April 12, 2022

Re: Serenity Amenity

This department has reviewed the plan you submitted for the Serenity Amenity swimming pool to be constructed on Piney Grove Rawls Rd, Fuquay Varina. This plan review was conducted in accordance with the current North Carolina Rules Governing Public Swimming Pools (15A NCAC 18A .2500).

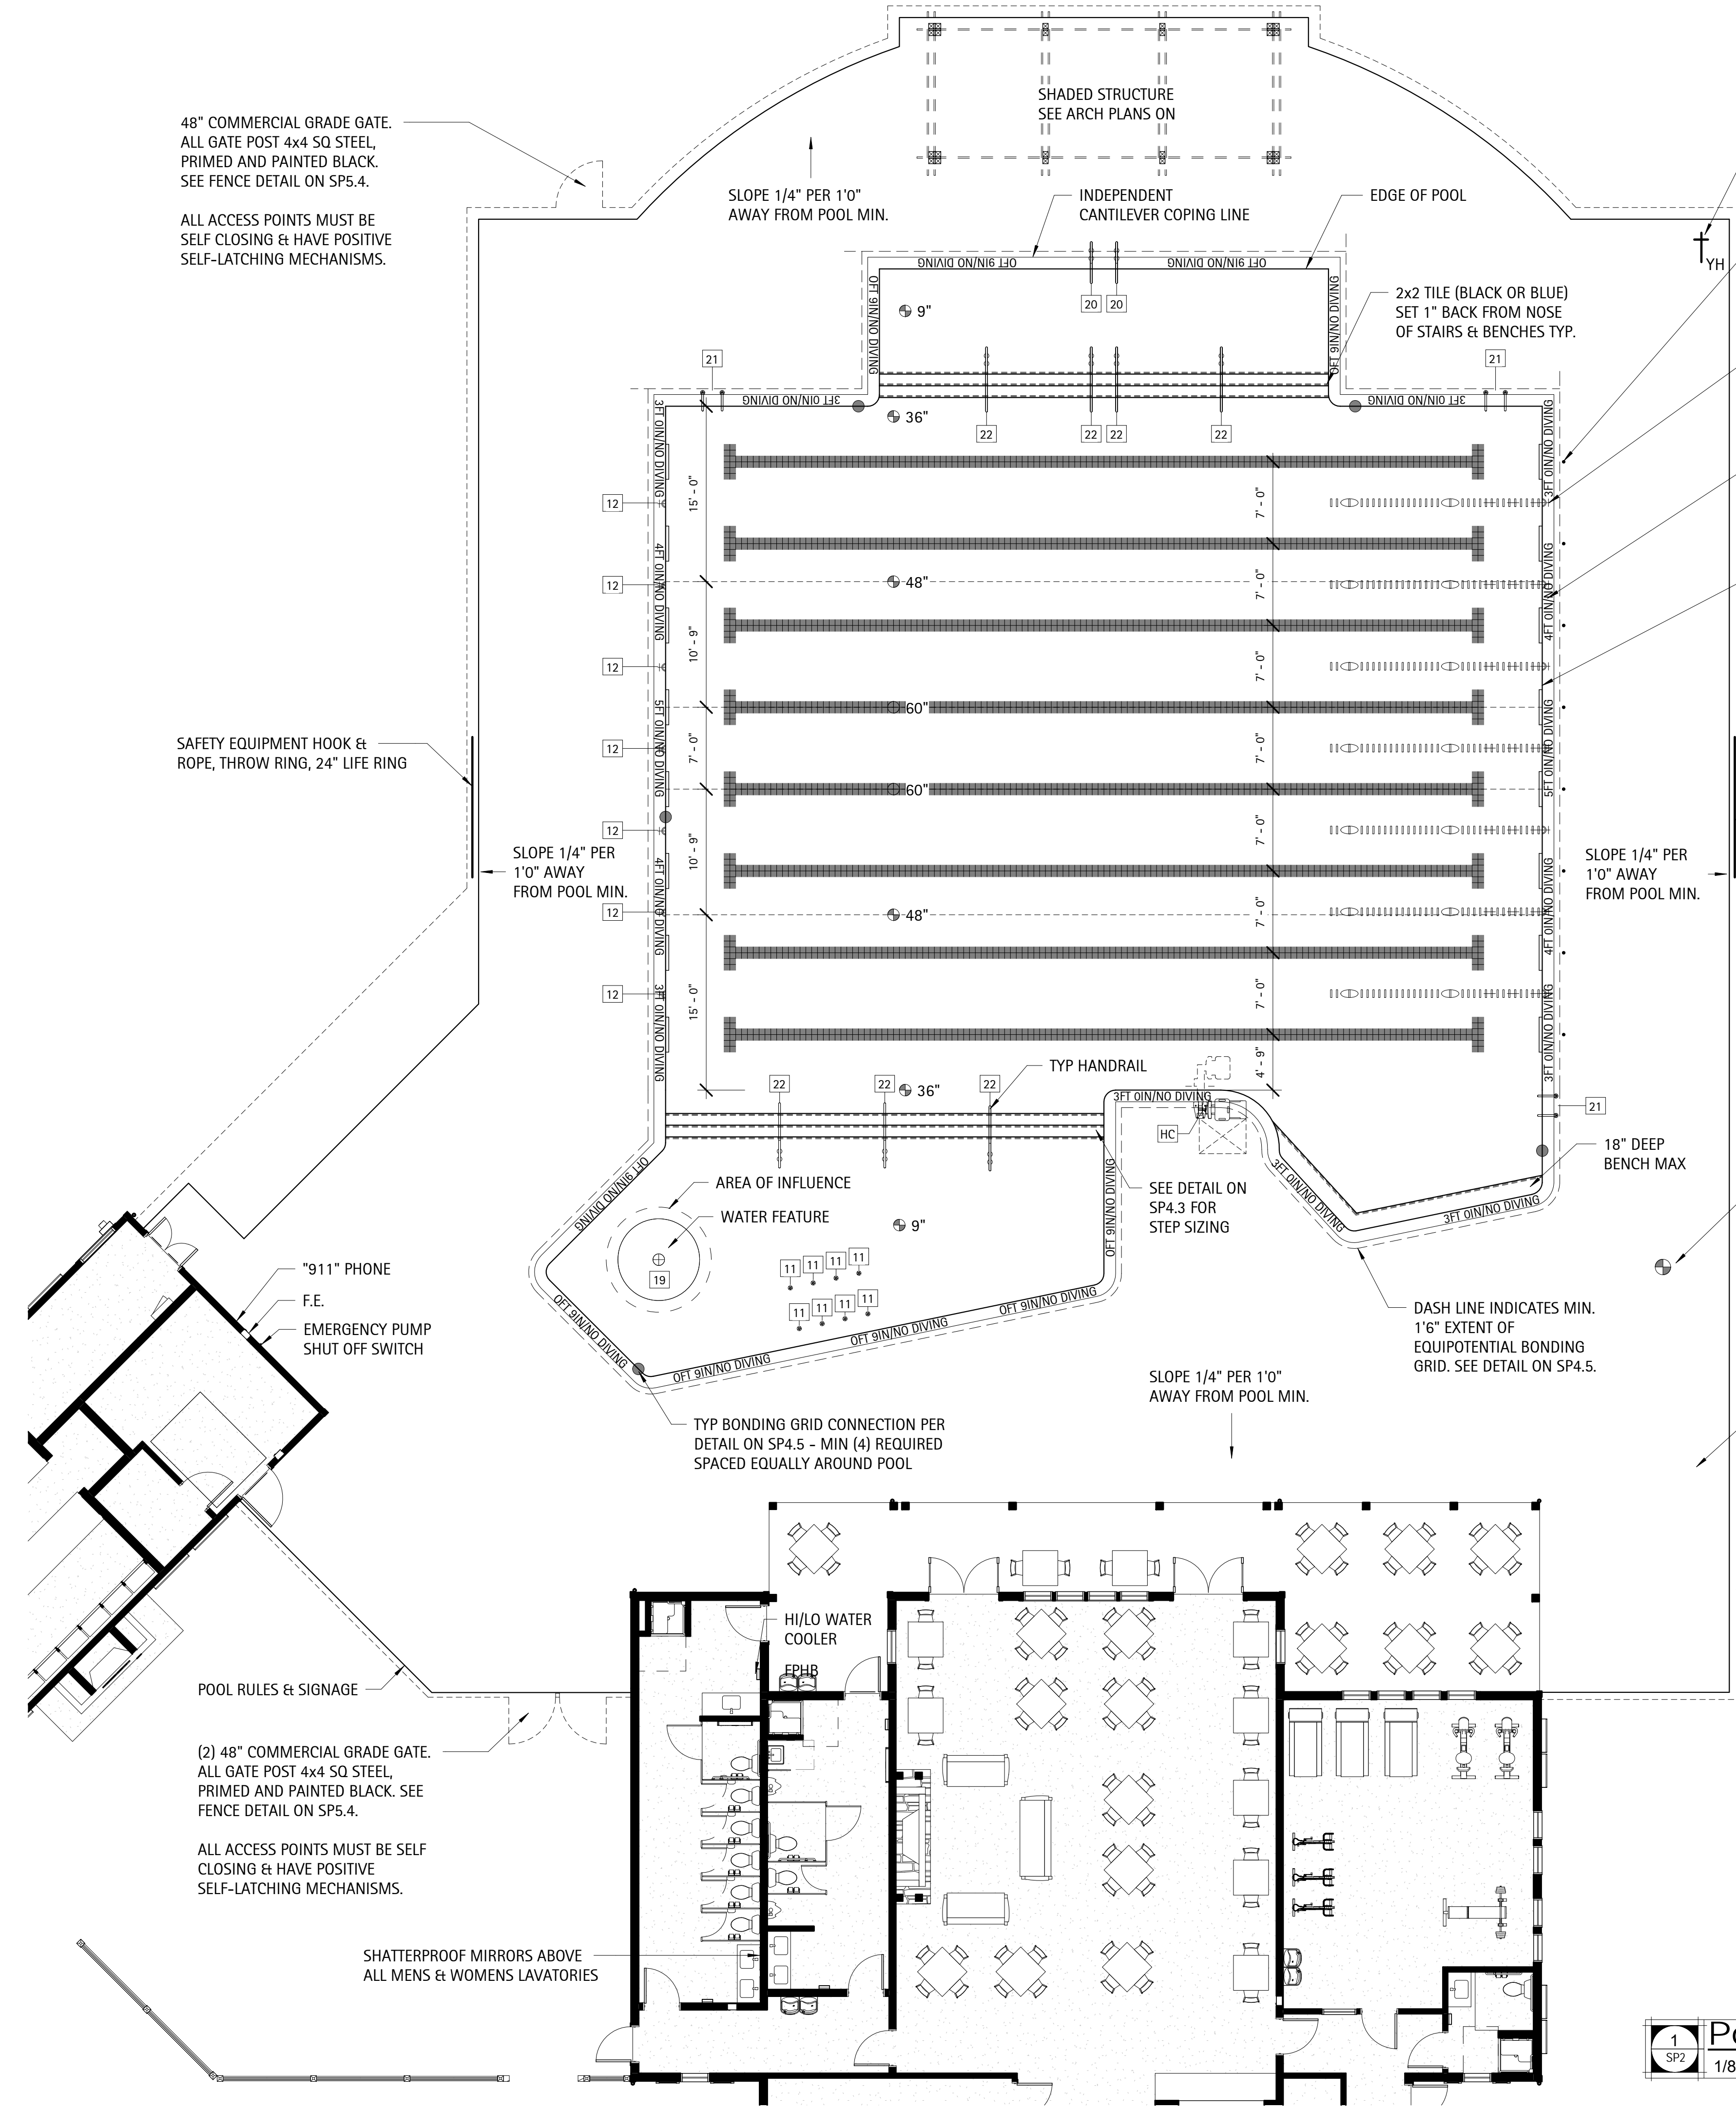
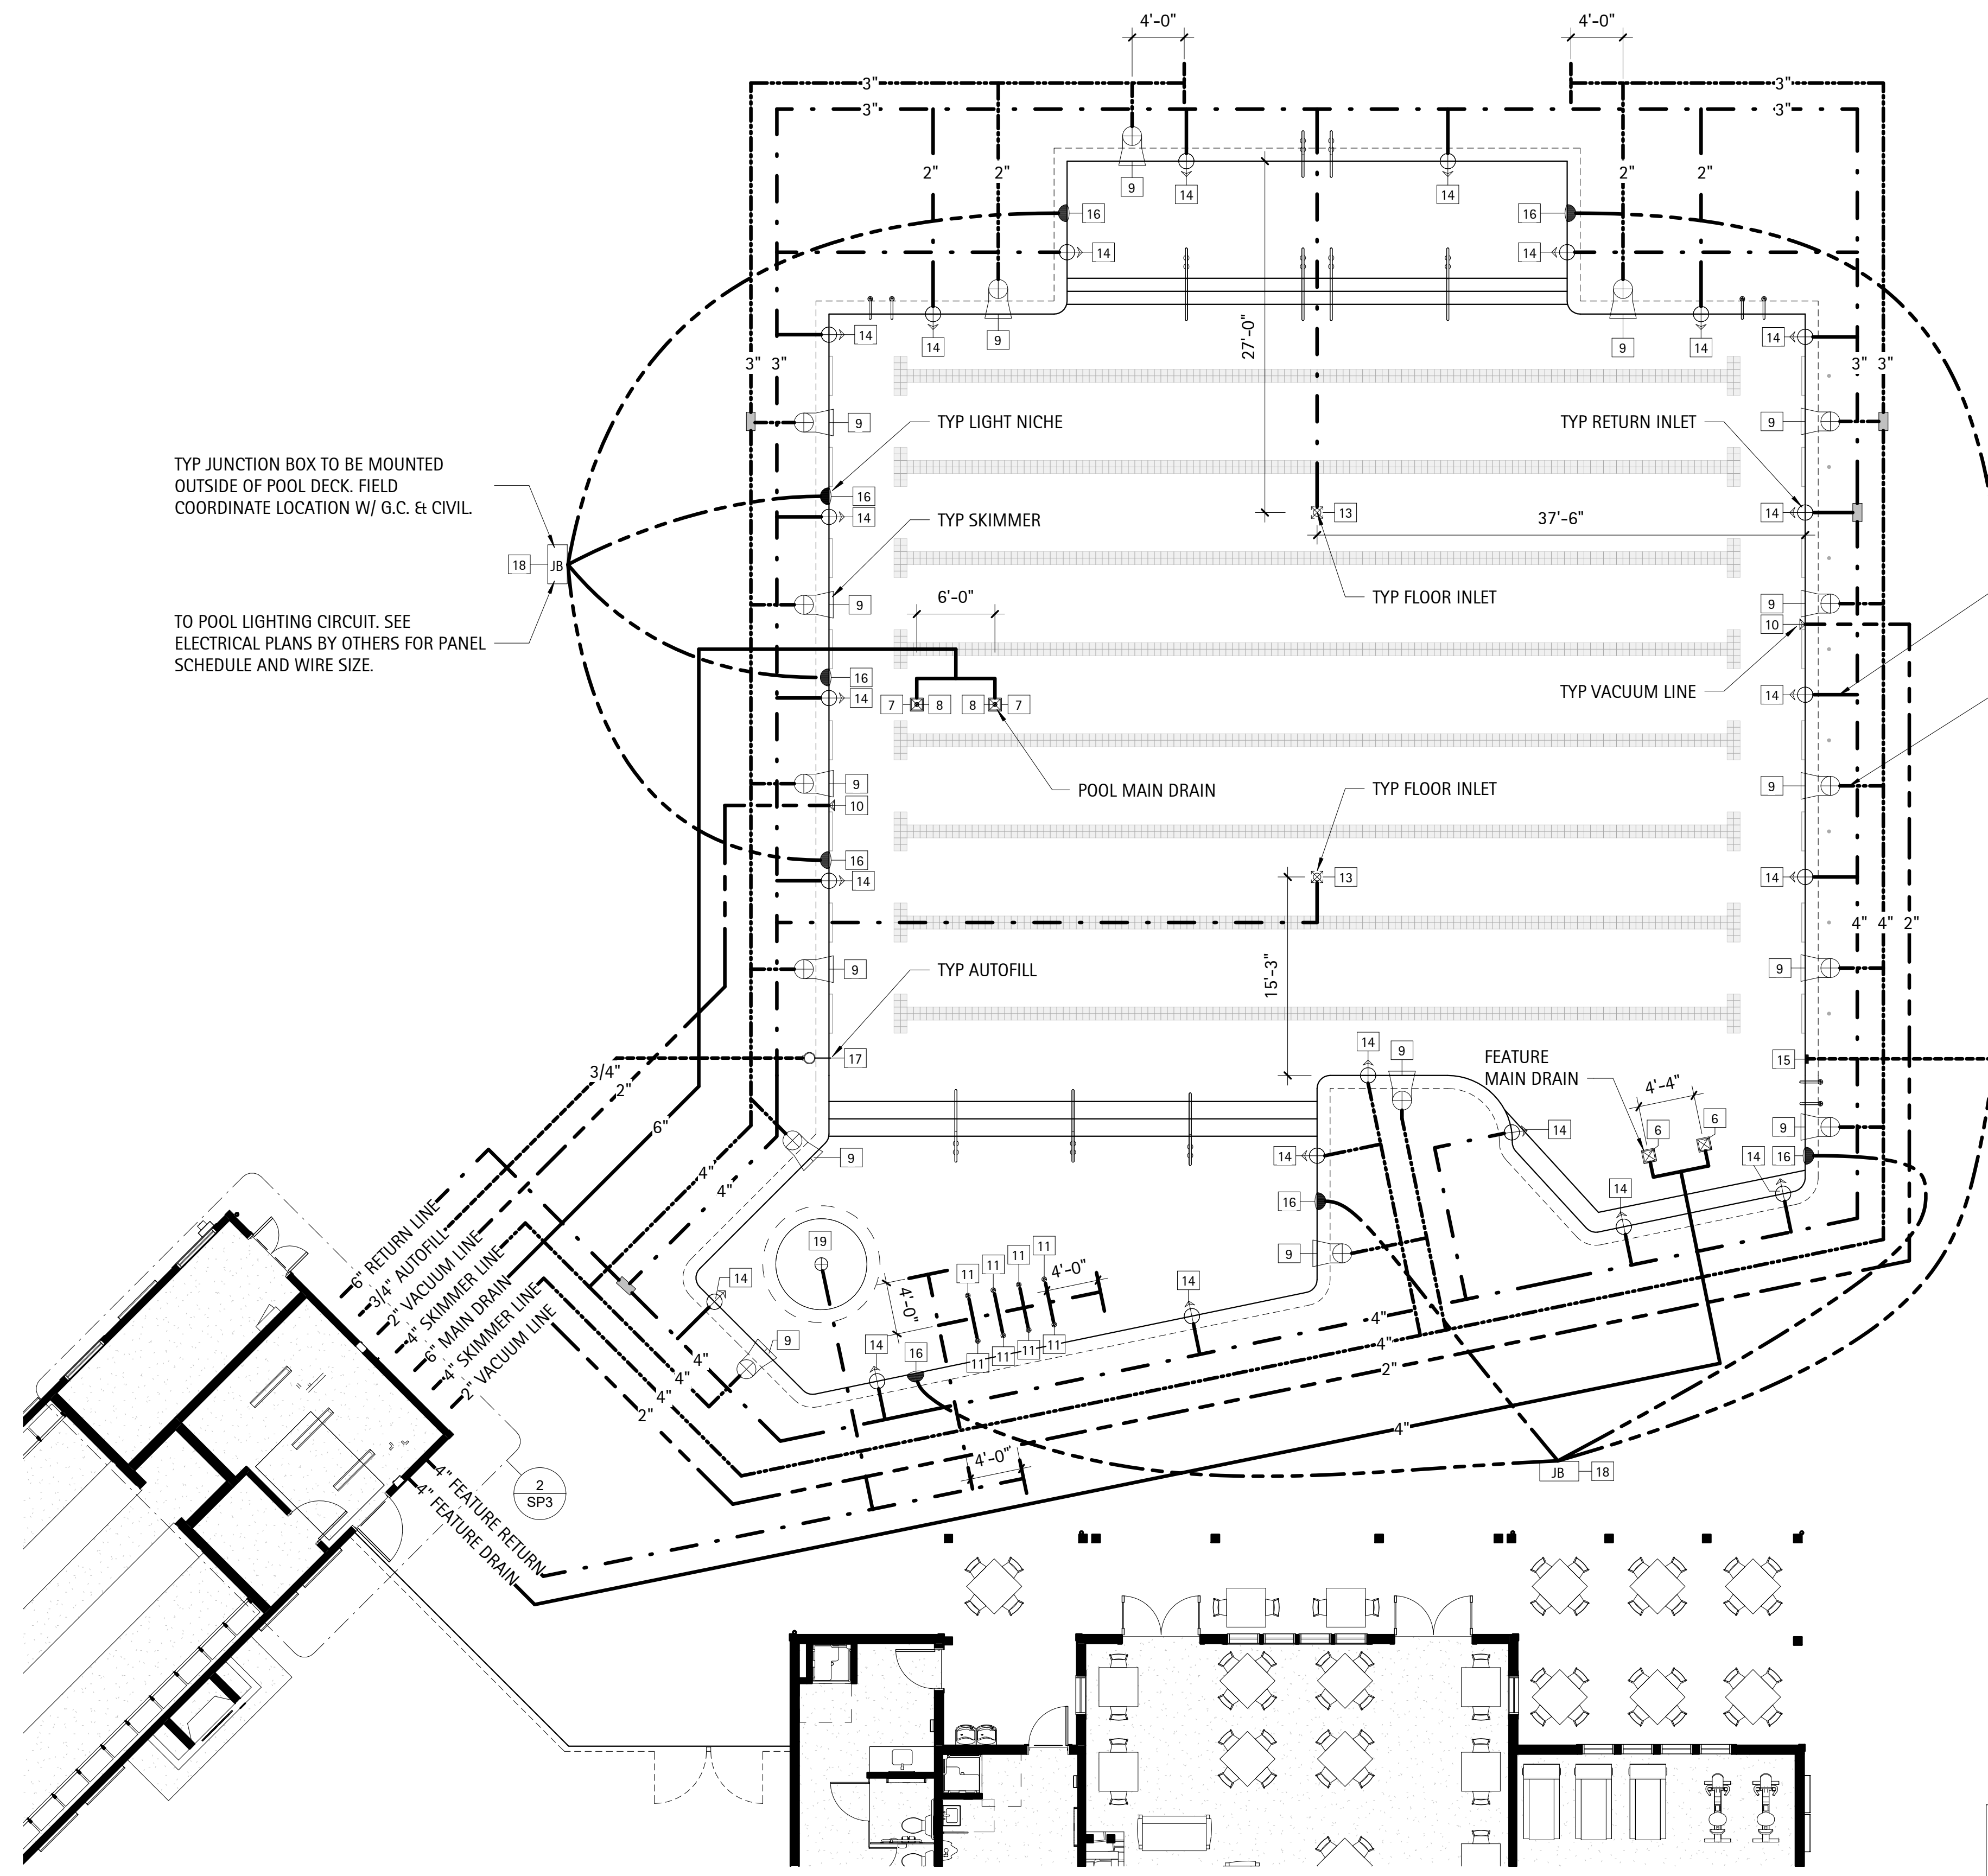
- Please clarify or correct plan regarding: two returns located in the vicinity of the handicapped chair lift section of the pool appear to be connected to the skimmer suction line
- Provide locations and specifications on deck drains
- Provide locations of hose bibs servicing pool deck
- Specify pool finish color
- Clarify whether a sight glass is provided with filter and valve assembly
- Ladder detail shows handrail not extending over side of pool to allow for assisted climbing at inset steps
- Ground level doors and windows opening from occupied buildings to the pool deck shall be self-closing or child protected by means of a barrier or audible alarm. Indicate which method will be used.
- Clarify whether there will be a shower on the pool deck or whether the showers in the bathrooms are intended for use prior to entering pool.
